## Inspector's Report ABP-313936-22

Whether works which comprise the rebranding of external shopfront signage to the existing retail unit is or is not development or is or is not exempted development.

49 Grafton Street, Dublin 2

EXISTING SHOP FRONT ELEVATION  
SCALE 1:50

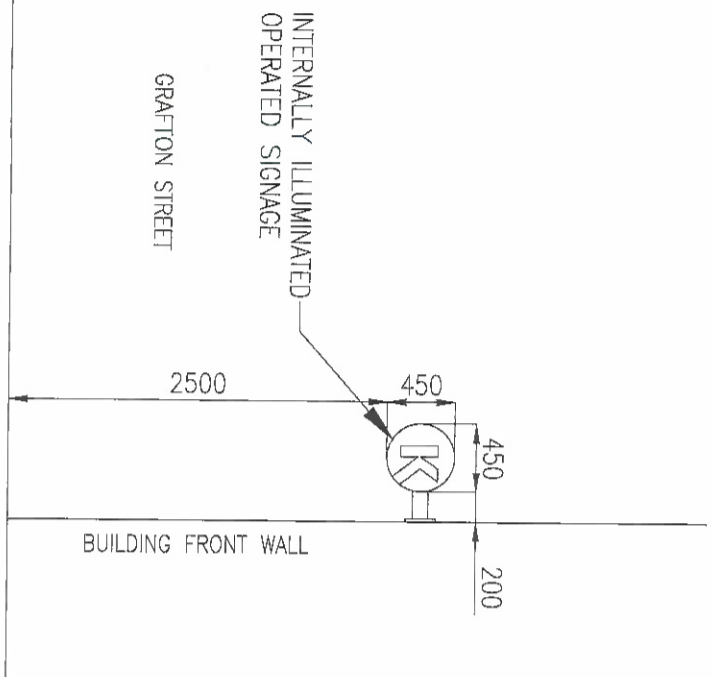
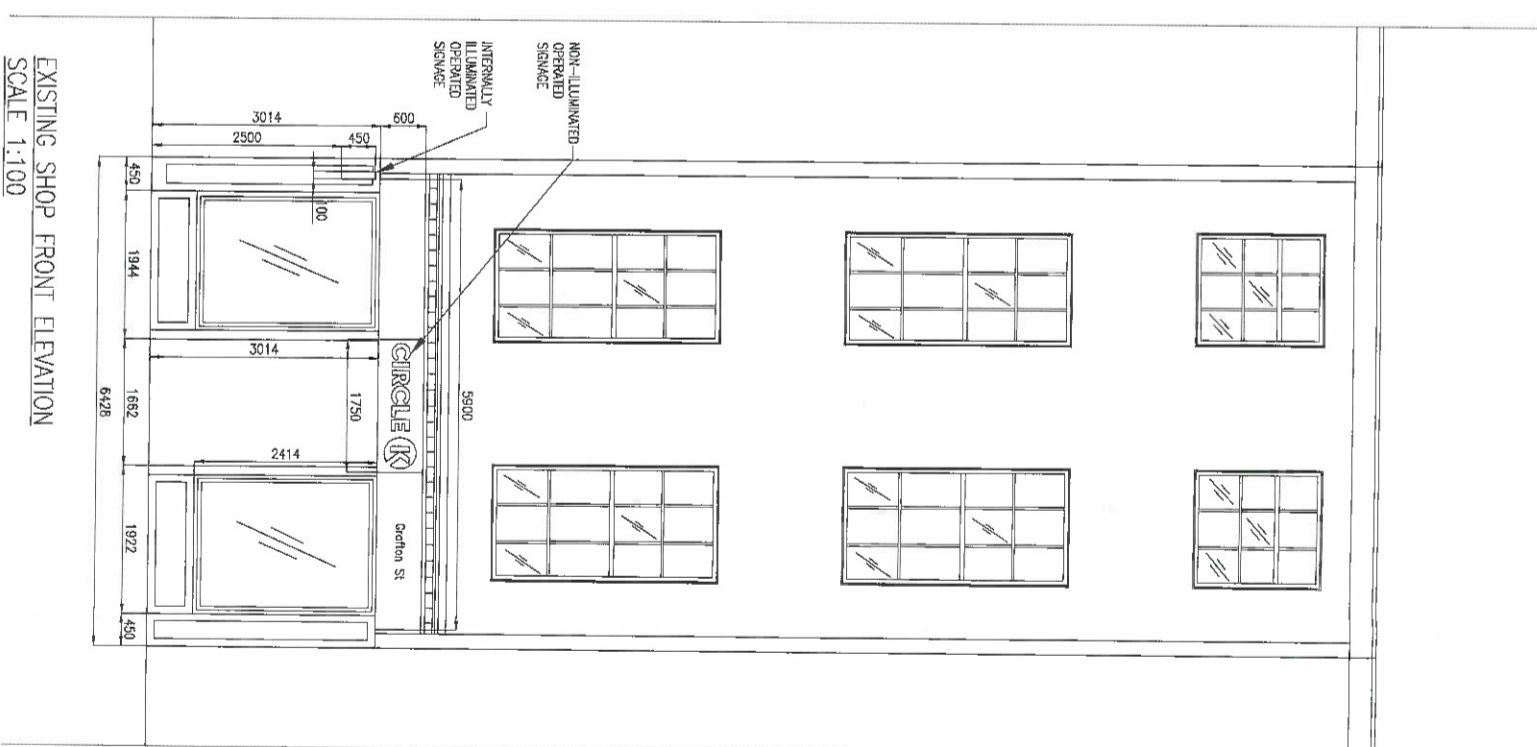
7.6 The planning authority note the listing of the property on the NIAH and having Regional Importance; its location within the Grafton St ACA and Area of Special Planning Control. The planning authority further note the failure of the drawings submitted to include the extensive unauthorised additional signage and branding on

7.11 Section 87 (1) of the Act states that 'Notwithstanding section 4 and any regulations made thereunder, any development within an area of special planning control shall not be exempted development where it contravenes an approved scheme applying to that area'. In this regard, I note that section 3.3.9 of the Scheme requires signage to form an integral part of the overall design for the shopfront; that the lettering employed shall either be painted on the fascia, or consist of individually mounted letters on the fascia board; size of the lettering used should be in proportion to the depth of the fascia board and in all cases shall not exceed 300mm in height. In this regard, the referrer does not give any details as to the material of the subject signage but states that it comprises the same type, size, materials and illumination as was already in place at the store. They further contend that no material change has arisen and that the replacement signage is consistent with the established and permitted traditional charter and style of the shopfront. I do not concur with this assertion. I consider that the subject signage is not in compliance with section 3.3.9 of the Scheme in that it does not form an integral part of overall design for the shopfront; the lettering employed is neither painted on the fascia, nor does it consist of individually mounted letters on the fascia board; the size of the lettering would appear to exceed 300mm in height (exact dimensions of same have not been specified). I do not consider that the replacement signage, (comprising of bright red signage, assumed to be PVC in material), to be consistent with the established and

permitted traditional character and style of the shopfront or of this NIAH listed structure, located within an Architectural Conservation Area.

7.12 In relation to Article 9 of the Regulations (cited above), the site is located within an Architectural Conservation Area and the works undertaken, which include for bright red PVC signage, are considered to be visually incongruous and have a detrimental impact on the character of Grafton Street Architectural Conservation Area and the Area of Special Planning Control. I consider that the existing signage negatively impacts on the character of the building itself and the streetscape as a whole. This is further exacerbated by the fact that there is additional signage present on the building that is not detailed in the submitted documentation.
